**From:** Laura Gibbons <Laura.Gibbons@arun.gov.uk>  
**Sent:** 26 October 2021 09:29  
**To:** Anita Gardner <Anita.Gardner@arun.gov.uk>  
**Cc:** Planning.Responses <Planning.Responses@arun.gov.uk>  
**Subject:** RE: Planning Consultation on: M/130/21/DOC

**Application No:** M/130/21/DOC

**Site Address:** 8 Manor Way Elmer Middleton-On-Sea PO22 6LA

**Description of Works:** Approval of details reserved by condition imposed under ref M/86/20/PL relating to Condition No 3 - surface water drainage.

CLIENT		George Bevis	
PROJECT		Manor Way Elmer	
TITLE		Proposed Surface Water Plan	
DRAWN	DATE	PROJECT NO.	
PR	Sept 2021		23605
ENGINEER	CHECKED	DRG. No.	REV.
MK	MK	201	
SCALE			
As Shown @ A1

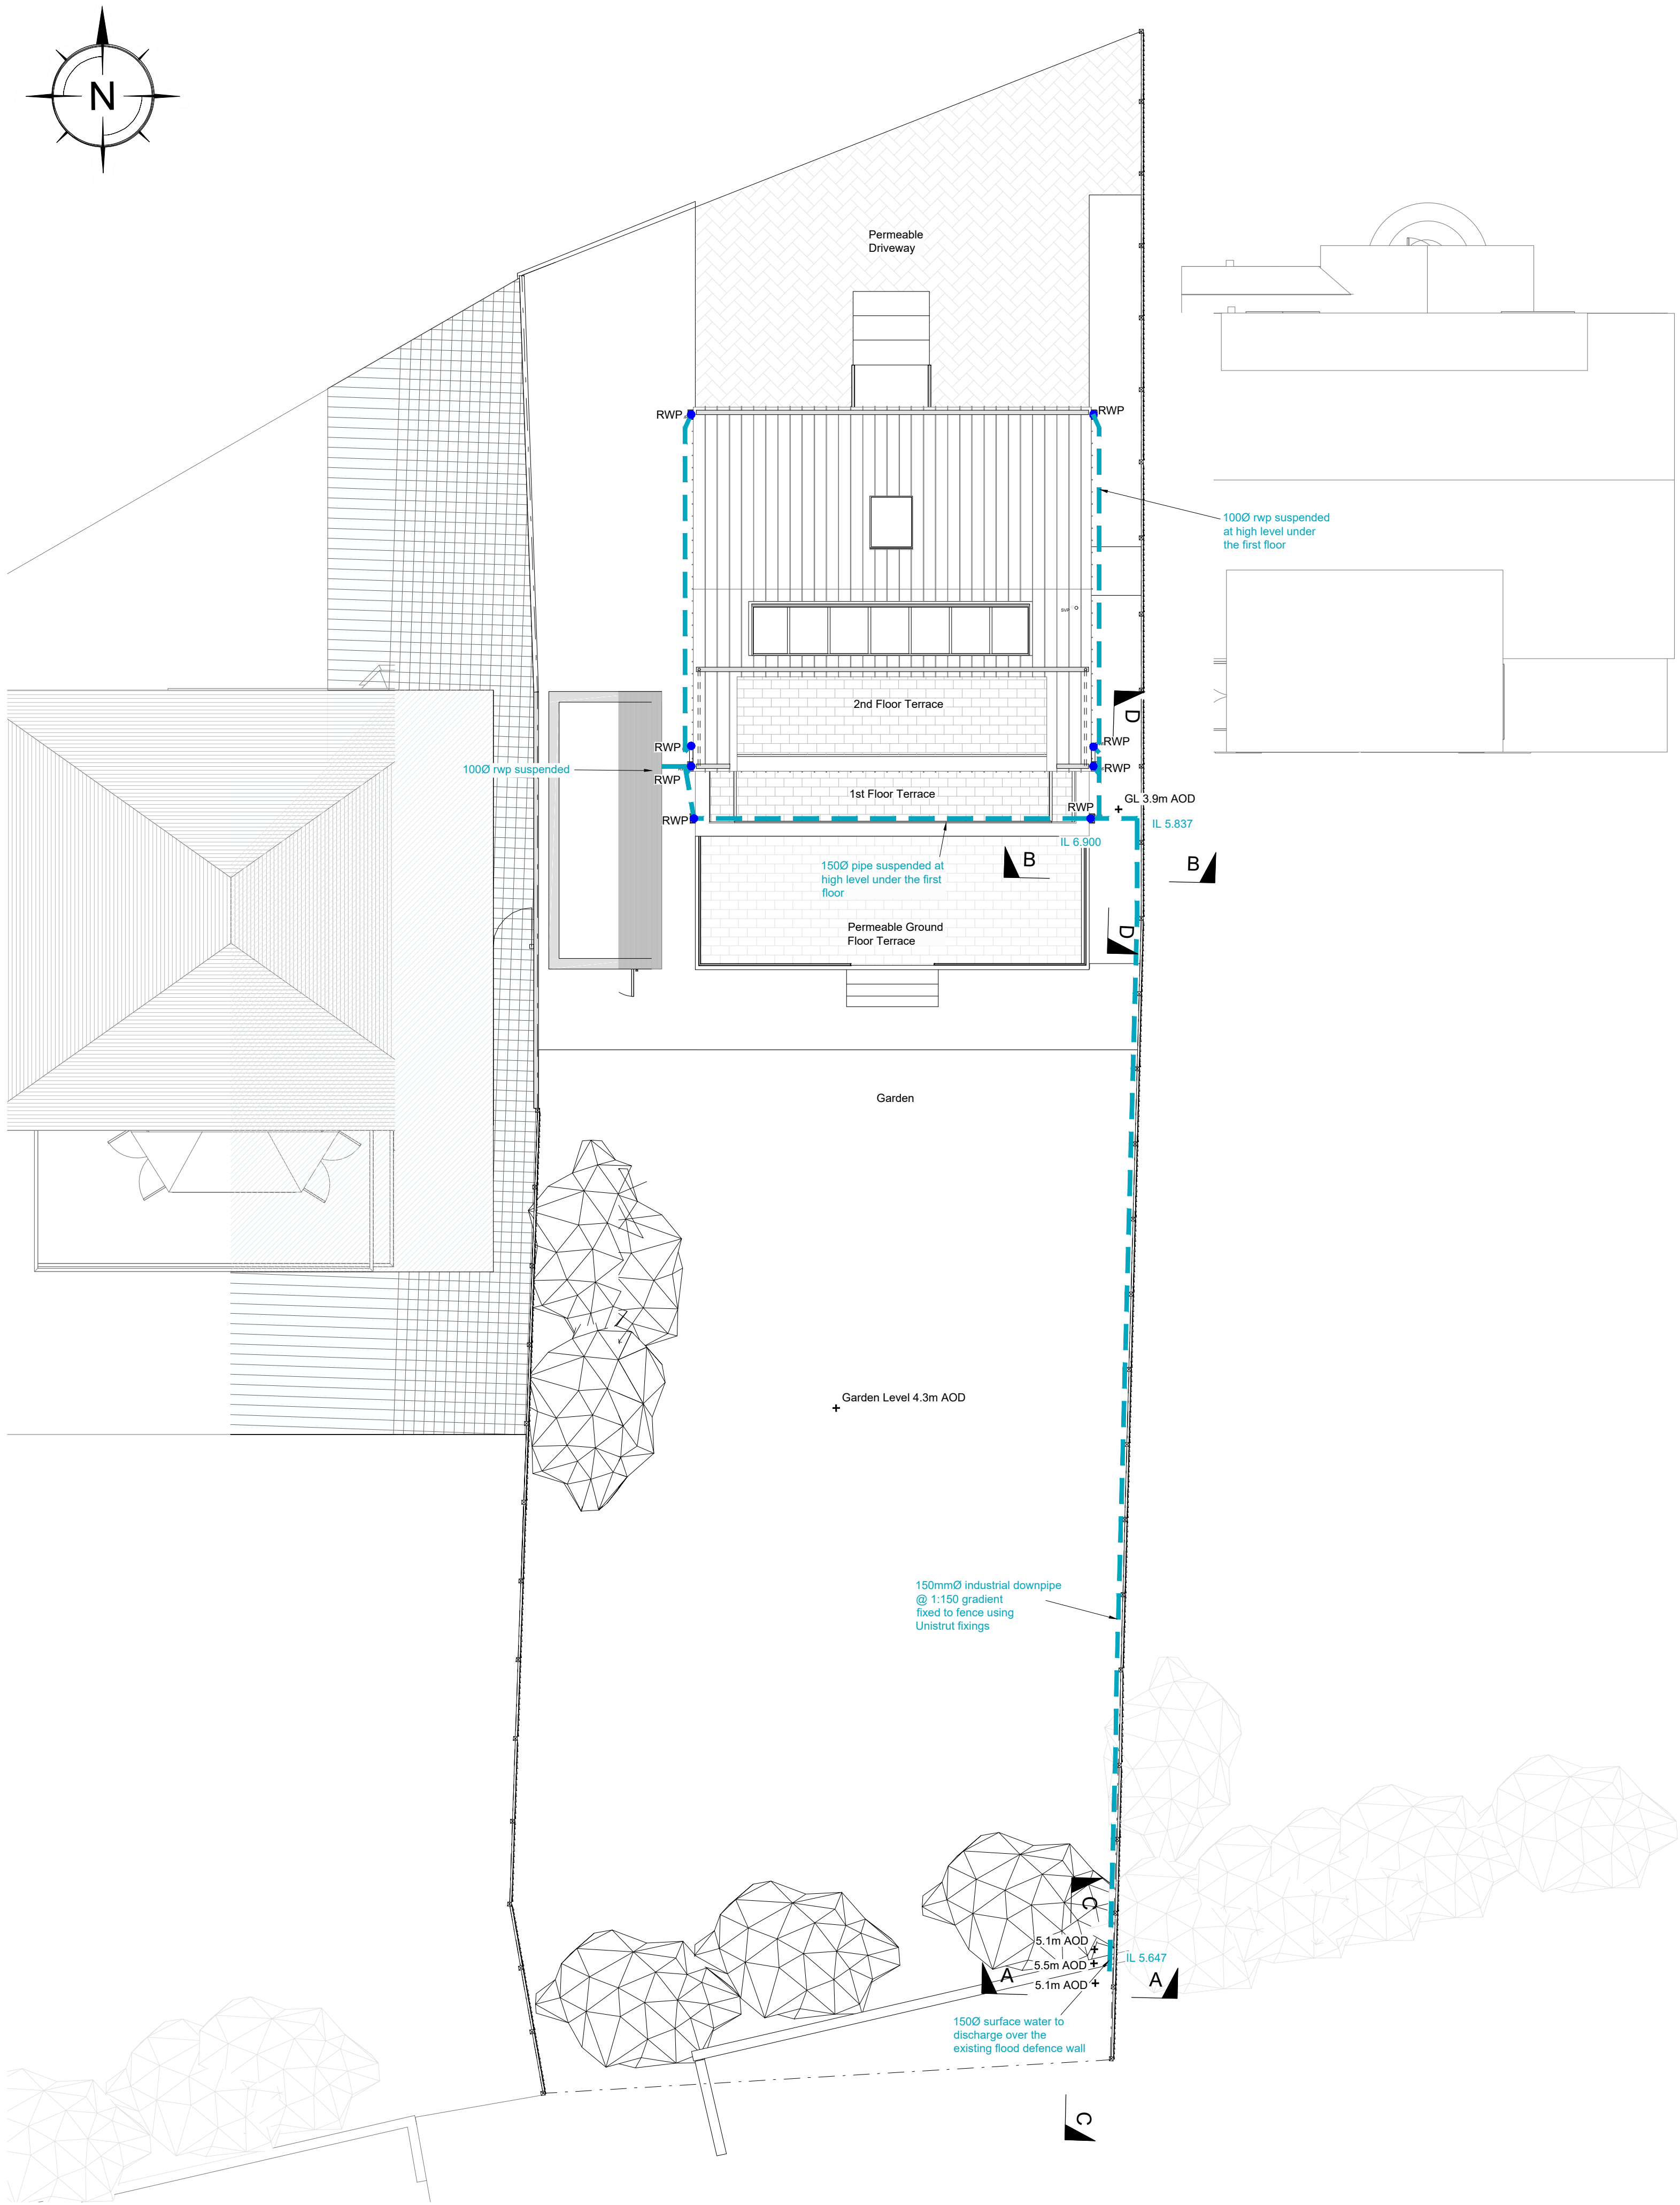
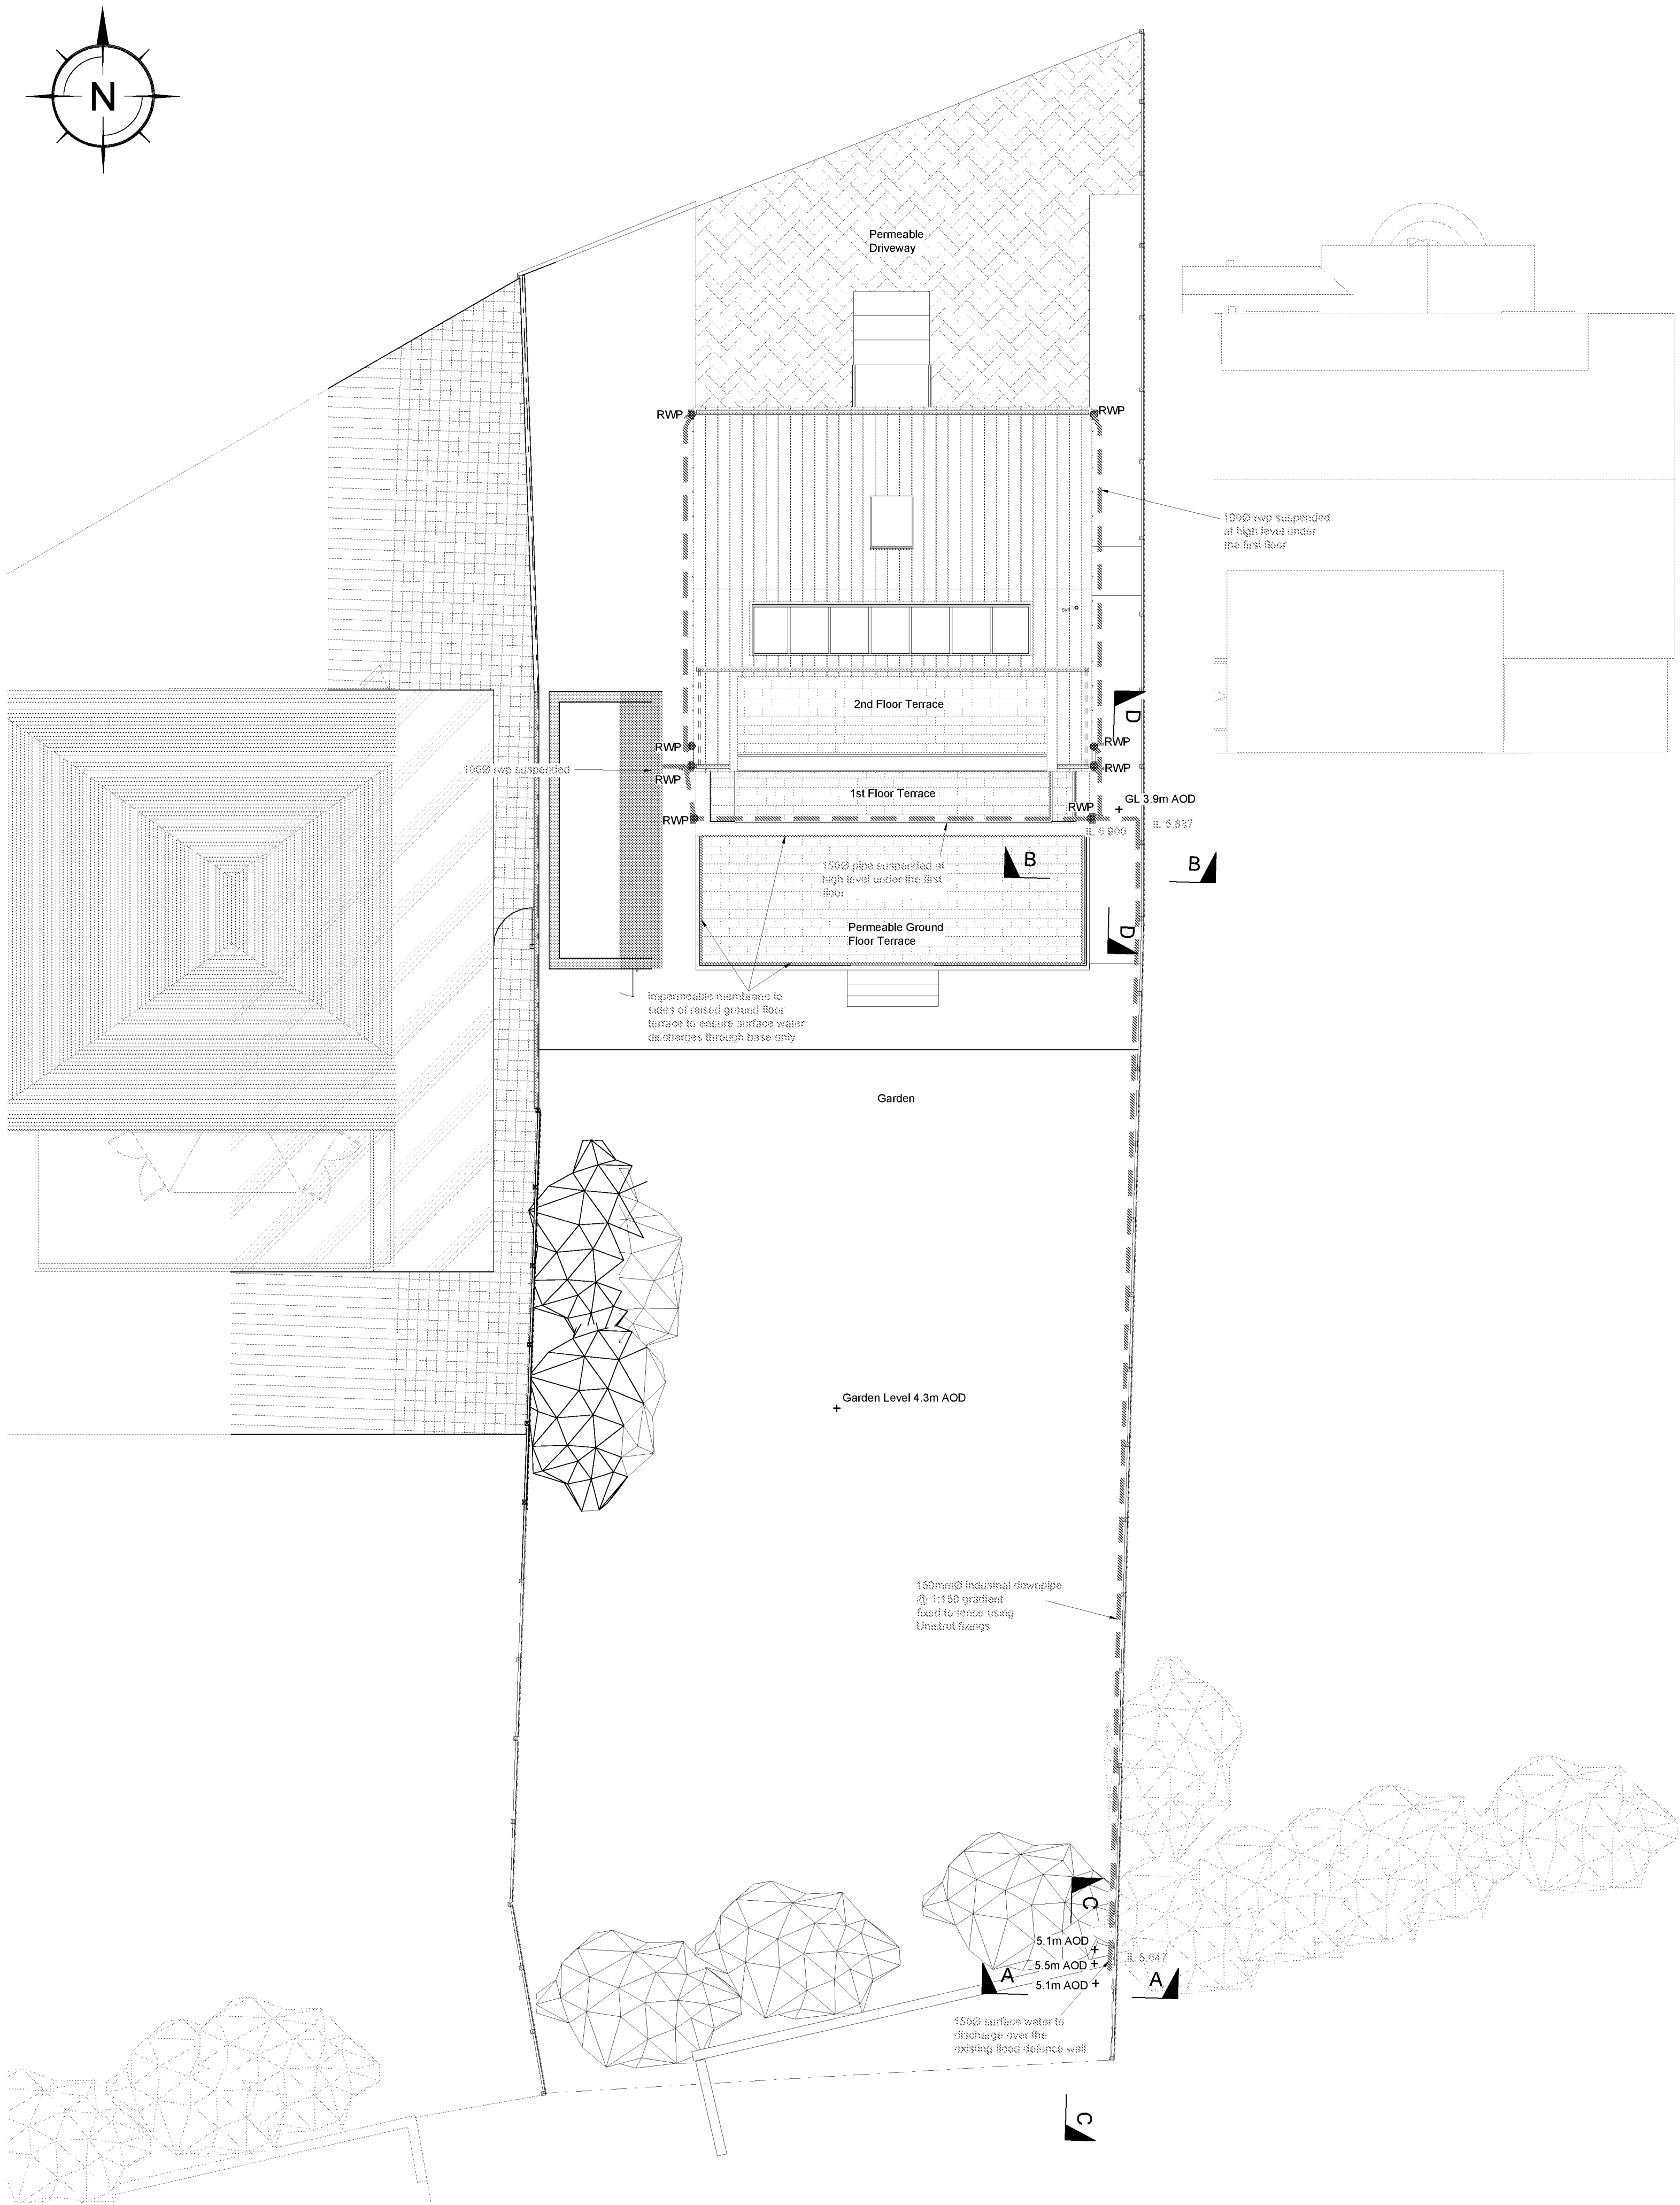
Please can an impermeable liner be provided to the sides of the rear garden ground floor terrace to ensure that water does not travel through the sides of this raised area and infiltrates through the bottom only.

Further to Laura's comment we have added an impermeable membrane to the sides of the rear garden terrace area on drawings 201A and 501A, copies attached. I trust this will allow the surface water scheme and Planning Condition 3 to be discharged.
